Your ref:  
Our ref: 21/01179/F  
Please ask for: Mrs Lesley Raby  
Direct dial: 01553 616818  
Direct fax: 01553 616652  
E-mail: borough.planning@west-norfolk.gov.uk

Details: **Two storey rear and side extension to existing dwelling. at The Chestnuts 69  
Lynn Road Wiggshall St Germans King's Lynn Norfolk**

I have received a planning application as detailed above but cannot process it until I receive some more information:

drawing title
Planning Section

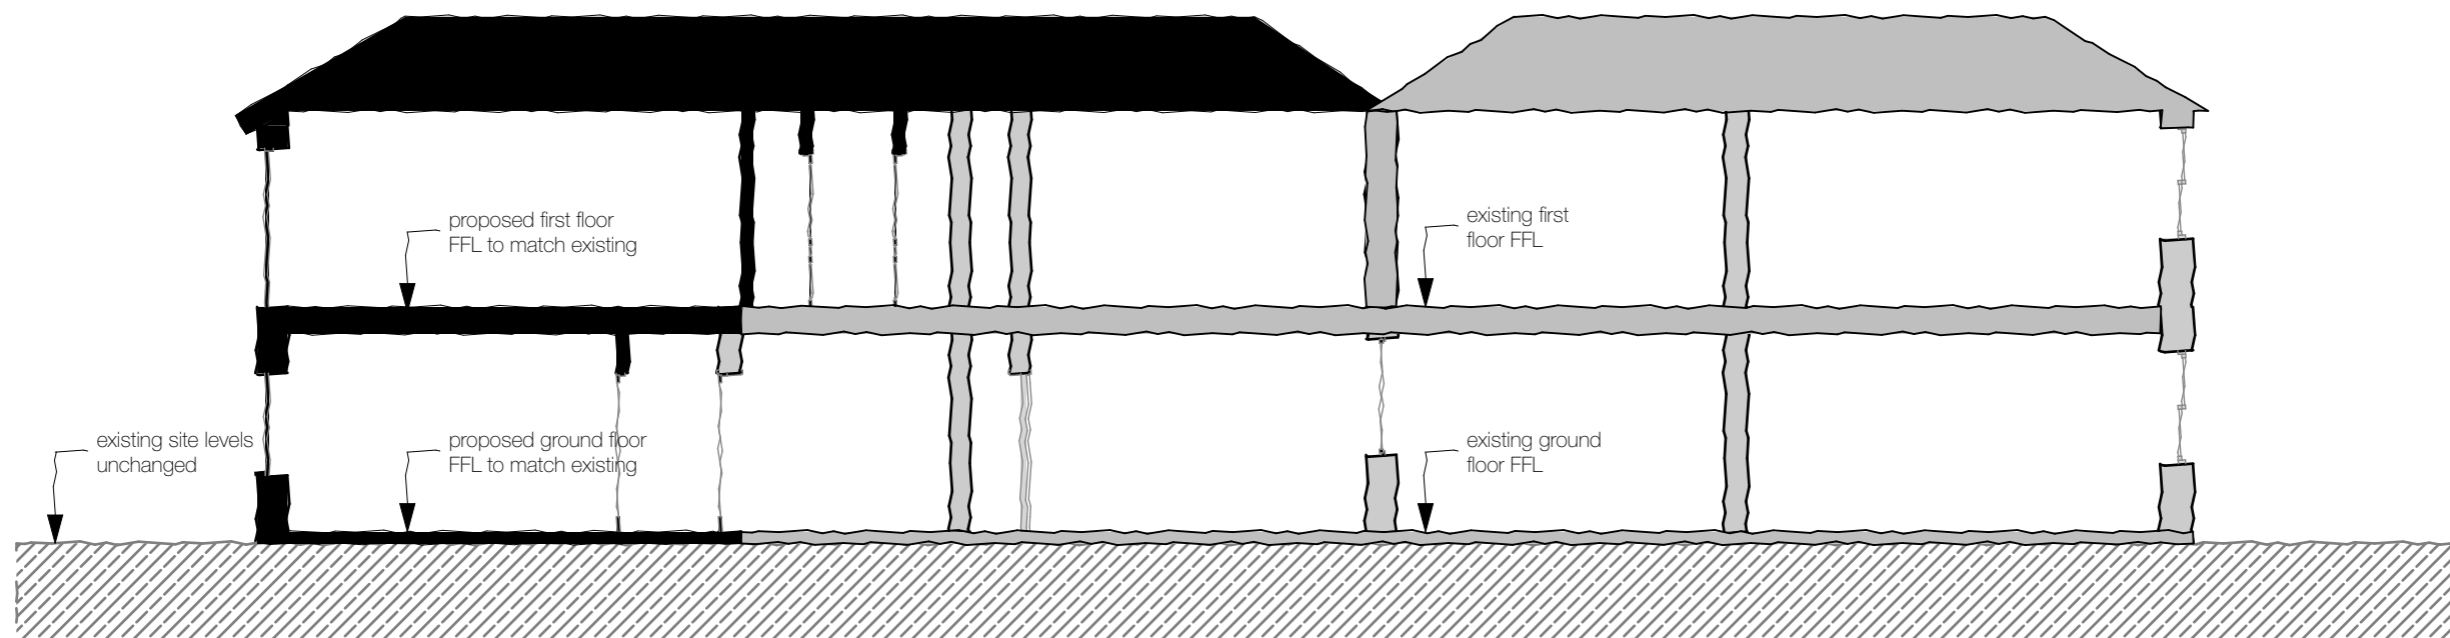
1. As the property lies within an area at risk to flooding, please complete the simplified Matrix and return it. The Matrix can be found at [https://www.west-norfolk.gov.uk/info/20173/information\\_for\\_planning\\_agents/231/flood\\_risk\\_information](https://www.west-norfolk.gov.uk/info/20173/information_for_planning_agents/231/flood_risk_information)
2. Provide a section through the extension to show the floor levels.  
Confirm that the site levels will remain unchanged.
